## WEST SUSSEX COUNTY COUNCIL CONSULTATION

| <b>FROM:</b>                    | WSCC - Highways Authority                                                                                                                                                               |
| <b>LOCATION:</b>                | 15-17 <u>Kew</u> Gardens<br><u>Bognor</u> Regis<br><u>PO21 5RD</u>                                                                                                                      |
| <b>SUBJECT:</b>                 | BR/63/19/PL<br>Demolition of existing building and erection of <u>6No. dwellings</u> , 2x 3 bedroom and 4x 2 bedroom with associated access and car parking.<br><br>Amendment received. |

BLOCK PLAN (1:500)

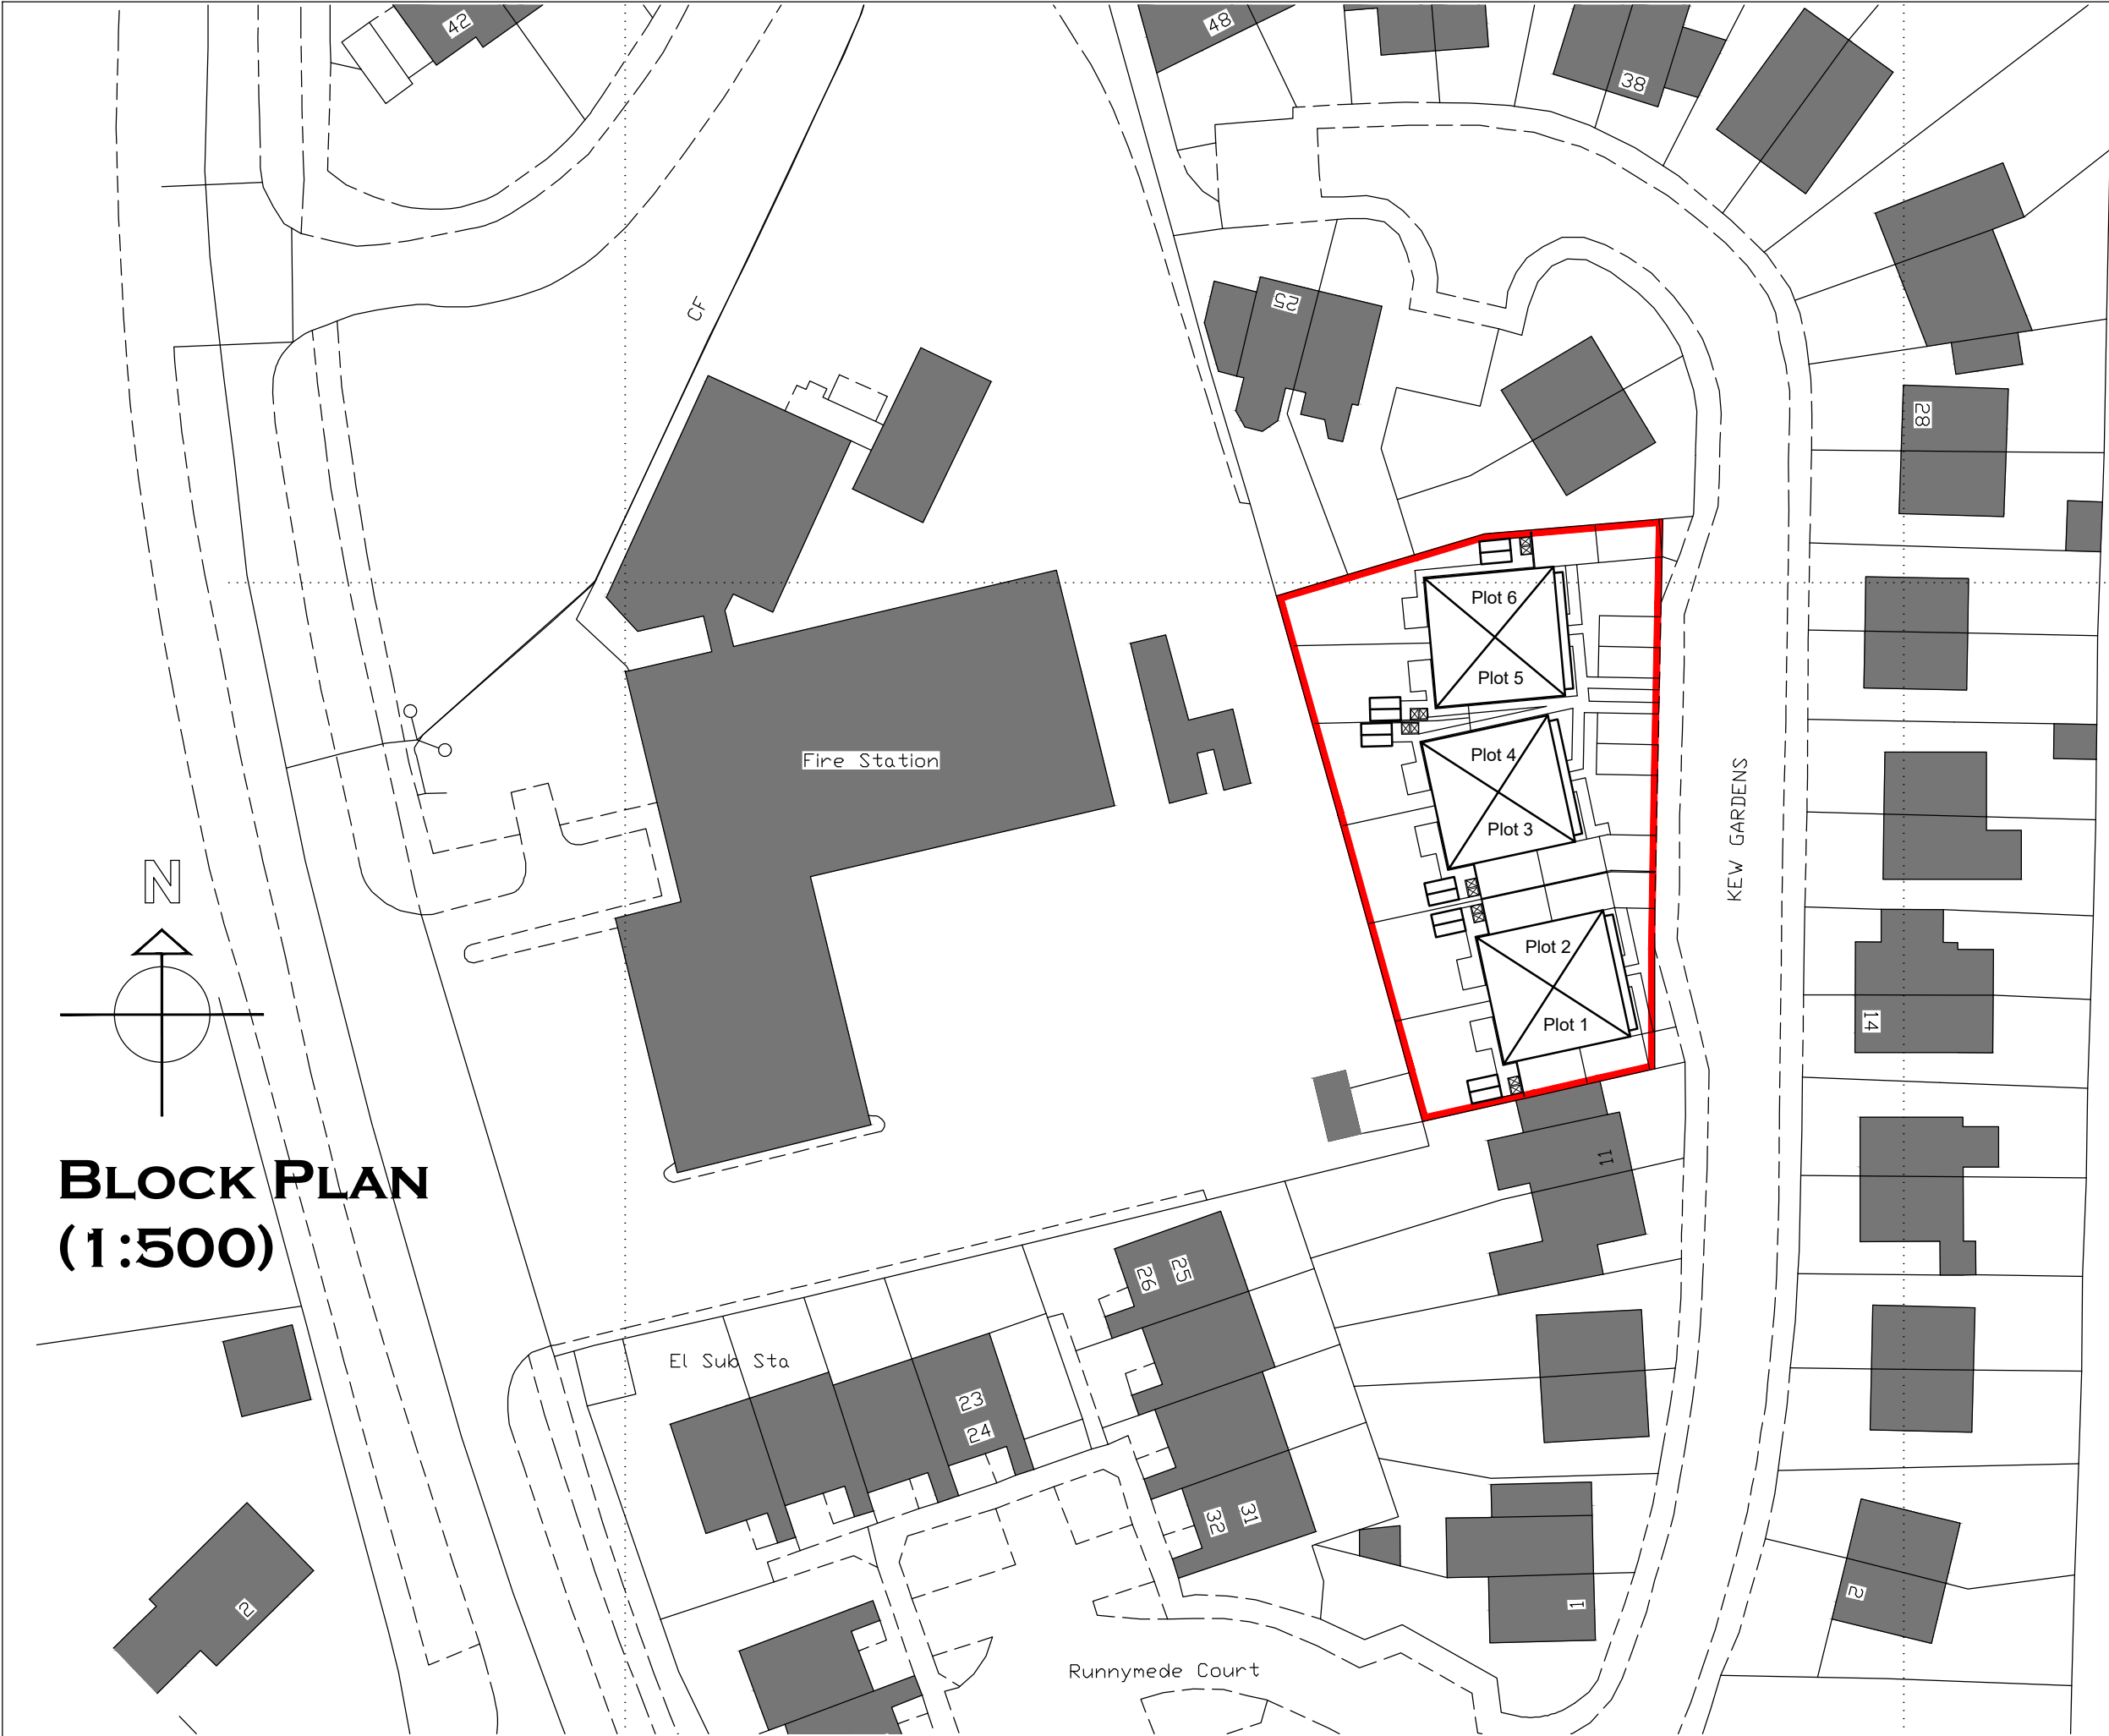
The revisions to this proposal result in one less access Vehicular Crossover onto Kew Gardens and therefore there will be less public parking space lost as a result of the proposal. The applicant should however refer to the Local Highway Authorities' previous comments made in relation to the proposal to create accesses within the layby as these comments still stand.

Due to the proposal not posing an increase in vehicular movements or increase in access onto Kew Gardens over that previously proposed, please refer to my previous comments sent 12/04/2019.
